Project # 1007367

Project Name: LANDS OF JOEL P. TAYLOR

Subject: Project #1007367, Site Development Plan for Building Permit, Riverside Church of Christ

**RE: DRB Final Sign-off of EPC Approved Site Development for Building Permit
Legal Description: A-1-B, Lands of Joel P. Taylor
Project # 1007367**

SITE PLAN (PHASE I),  
SITE DATA, SITE PLAN  
(PHASE II)  
SHEET NO.

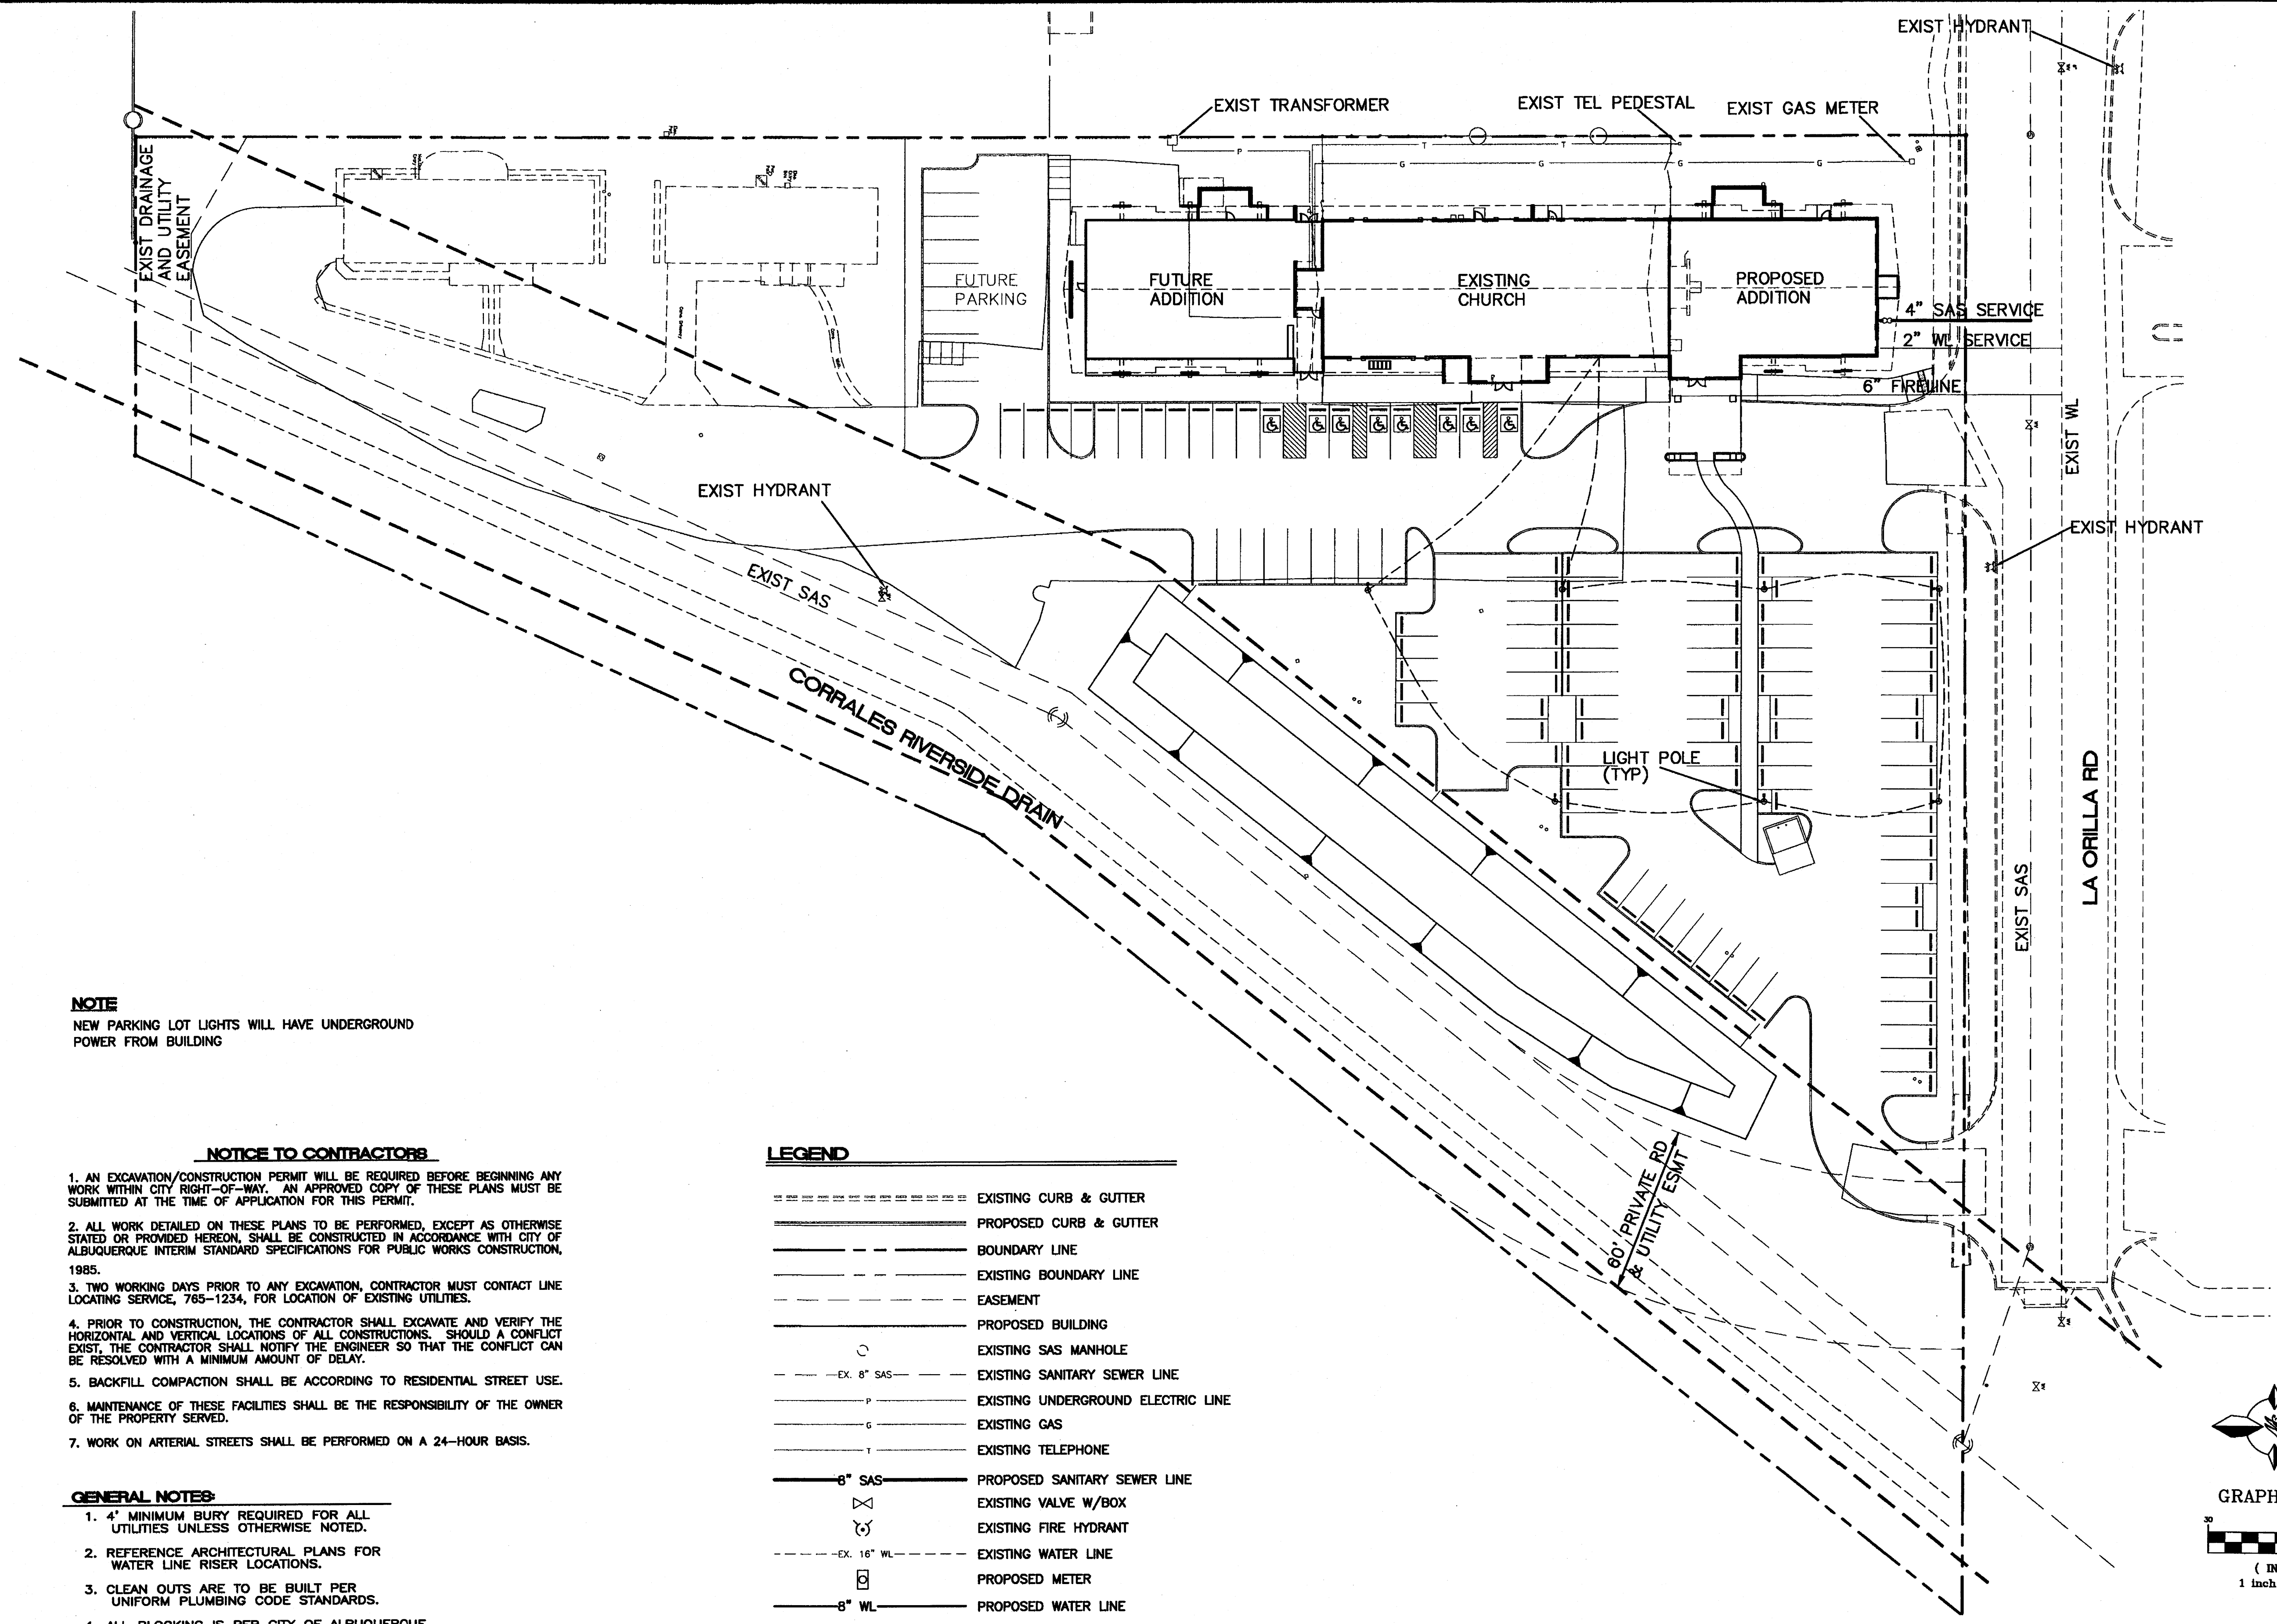
3. Site Development Plan:
 - a. The label for the area of asphalt within the 100' buffer zone that will be removed in Phase I shall include "and replace with landscaping".
The note is revised on Sheet A101.

- c. Provide an ADA accessible connection between proposed sidewalk adjacent to buildings and the existing sidewalk/ramp adjacent to La Orilla Road, at the NW corner of the main drive aisle entrance with La Orilla.

- e. Delete parking spaces 106 and 107 to increase throat length at east site drive.

5. Vehicular Access, Circulation and Parking: All small car spaces shall be called out on the site development plan and reflected in the parking calculations (19 total).

9. A motion detection light shall be used for security purposes at the main entrance and adjacent parking area.

This is shown on the Sheet A101.

This is shown on the Sheet A101.

This is shown on the Sheet A101 in the Site Data Table.

This note has been added to the Site Plan (Sheet A101) under the Zoning Code Notes.

Sheet Title:  
**Landscape Plan**  
 Sheet Number:  
**LS-01**

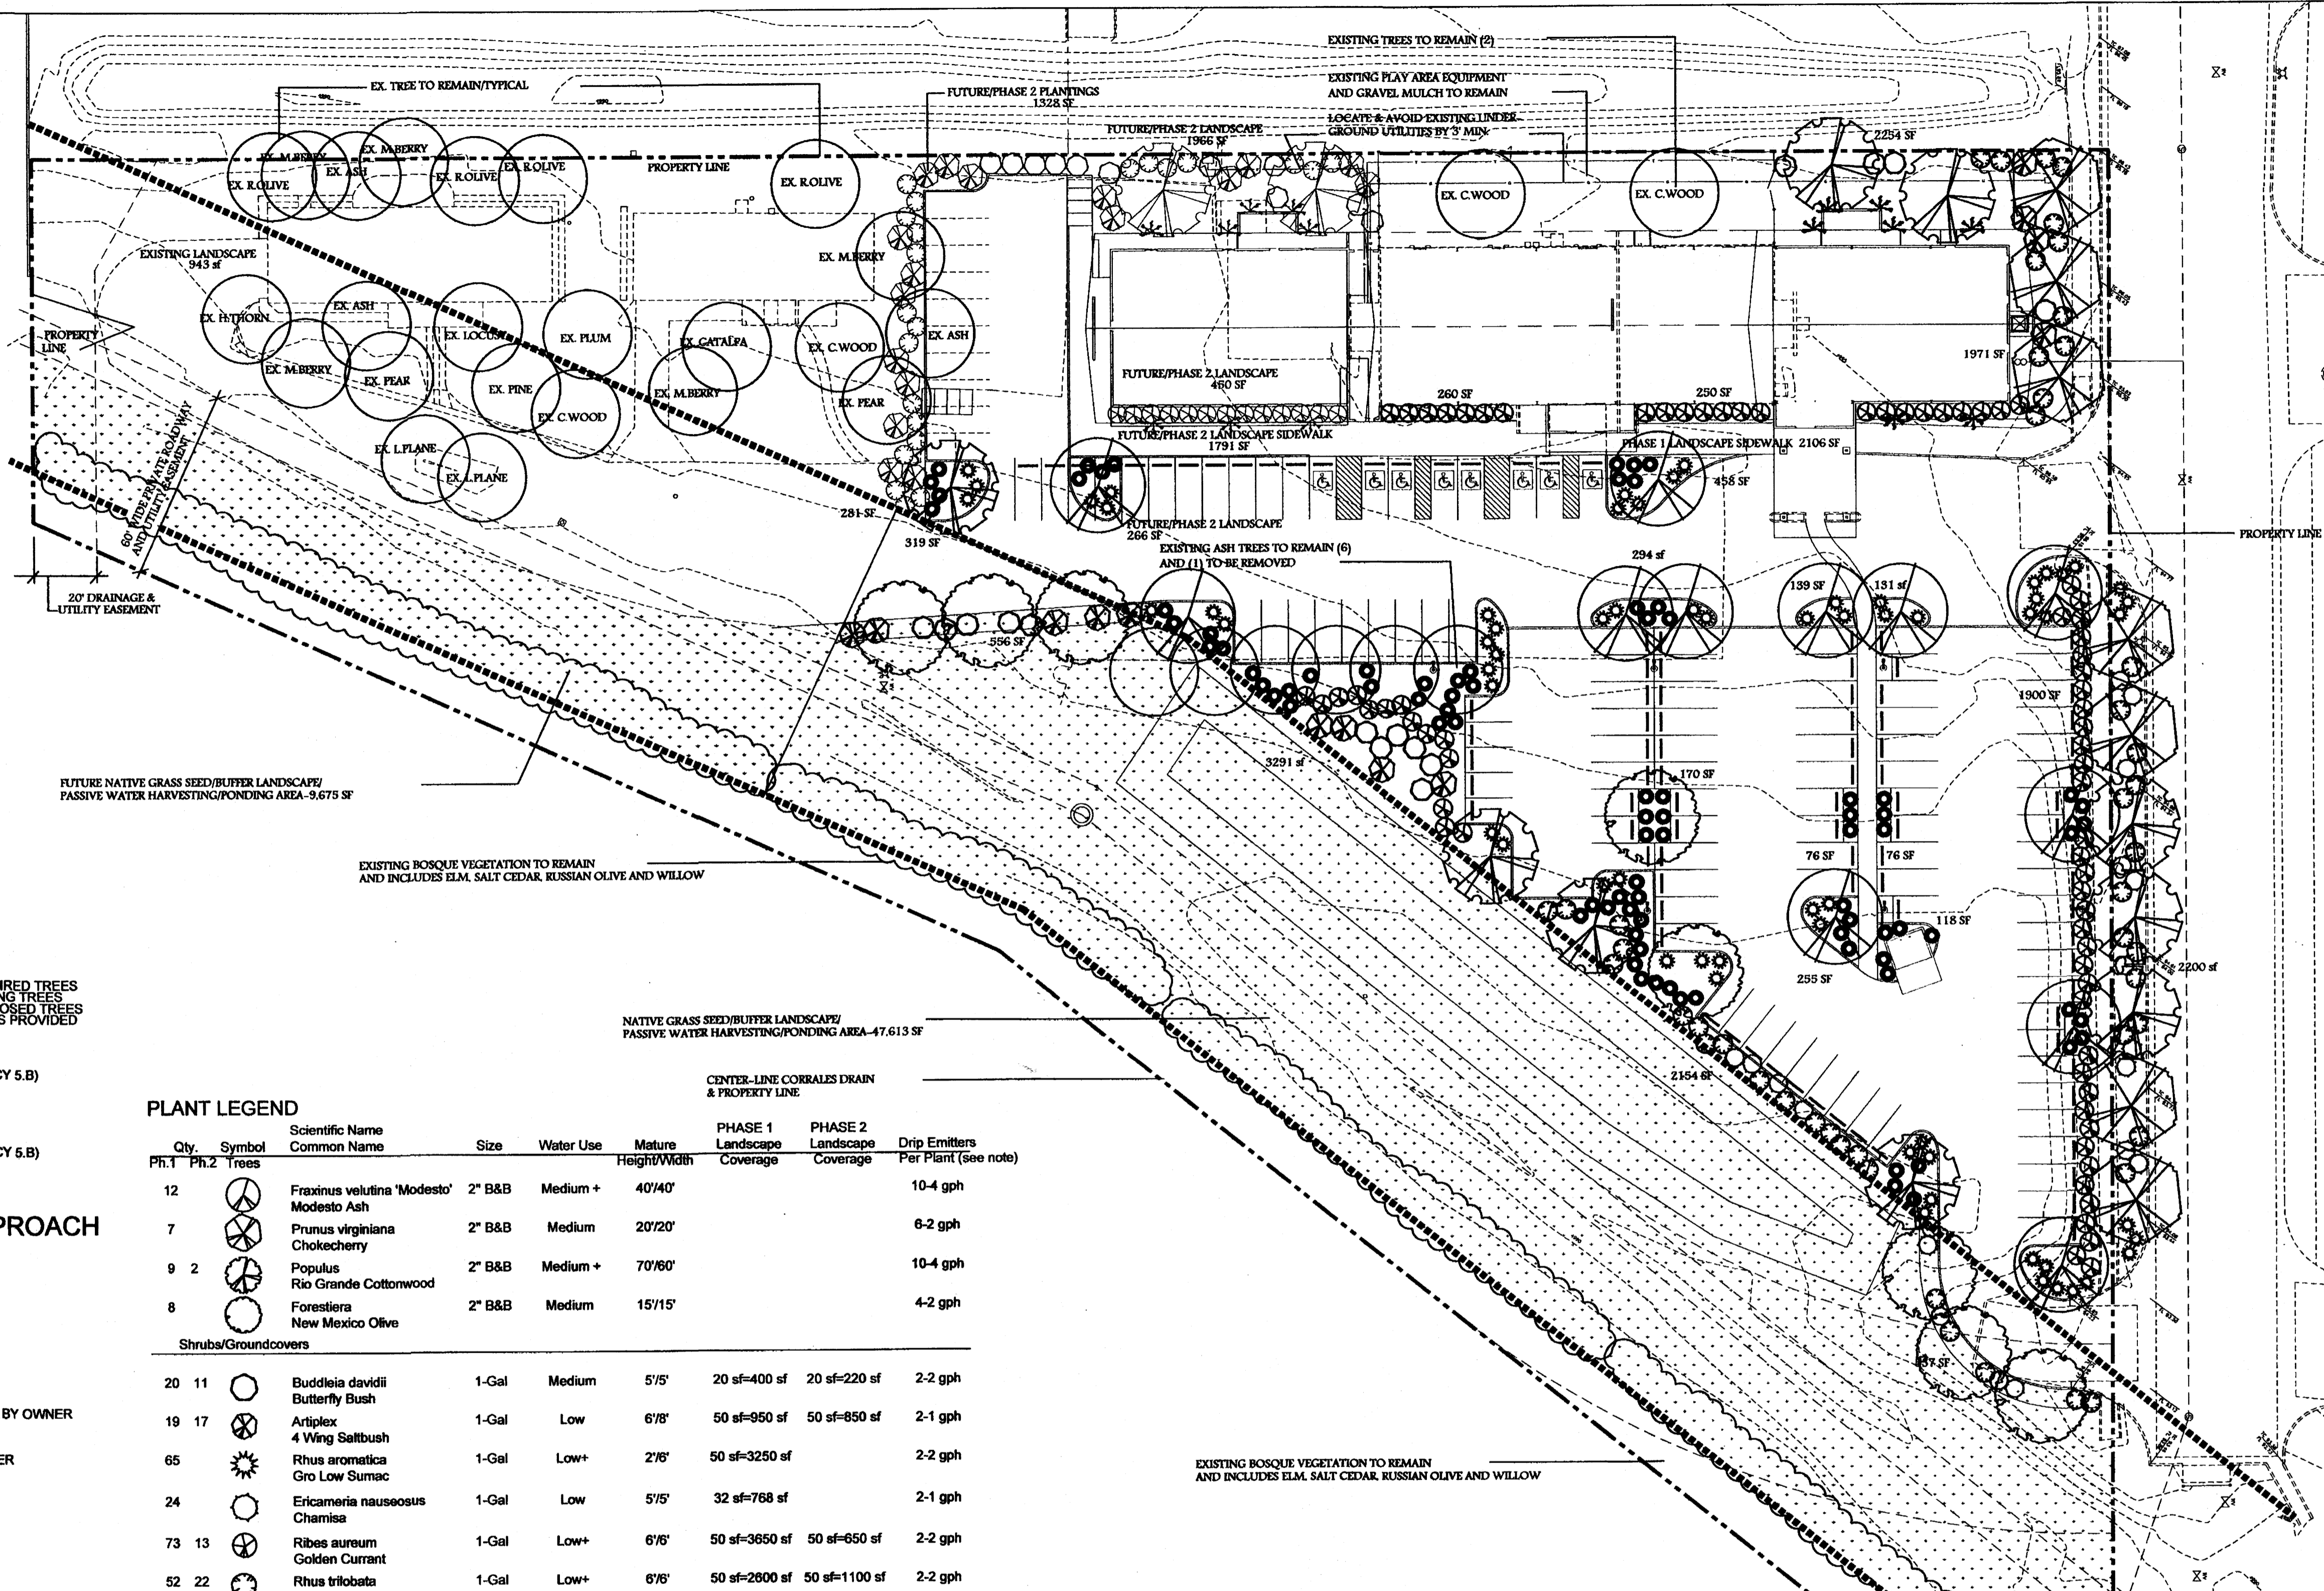
- a. Shrubs and New Mexico olive shall be added next to the site drives at the north and south ends of the retention pond to provide a transition between the developed area and the buffer zone.

- b. In the landscaped bed west of the church addition, move the trees and shrubs at least 3' from the underground gas line.

- c. Two thirds of the street trees shall be shade trees, per the Street Tree Ordinance, and shall include Rio Grande cottonwood.
Rio Grande Cottonwood has been added to the street trees and the number increased to comply with the Street Tree Ordinance.

- d. Calculations:
- Landscape area in the ROW is 2,200 sf., which shall be subtracted from the total lot area and then added to the landscape area provided;
The ROW landscape area of 2200 SF was subtracted out of the calculations.

- Delete line beginning "1/3 may be sidewalk...";
This has been done.
 - The 20% parking area landscaping requirements shall refer to Off-street parking Policy 5.B in the Coors Corridor Plan.
This is shown in the Site Data Table on the Landscape Plan.

- e. Plant legend:
- Change mature spread of Artiplex (four wing saltbush) to 6' X 8'. Adjustments to the number of plants and coverage shall be made according to achieve 75% minimum live ground cover.
This is shown on the Landscape Plan.

- Include native grass species in plant legend.
Native grasses are shown in the Plant Legend.
- f. Change note on drip system (last note) to provide shade trees with 150 gallons per week during establishment, per City Forester's standard guidelines.
This note was added to the Landscape Plan as directed.

- g. The native grass species in the buffer zone shall be reseeded for three consecutive years.
This note has been added to the Landscape Plan.
- h. Trellises shall be used for climbing vines.
Trumpet vines have been added to the trellis locations.

This is shown on the Landscape Plan (Sheet LS-01).

Trees and shrubs have been moved to avoid the existing underground gas line.
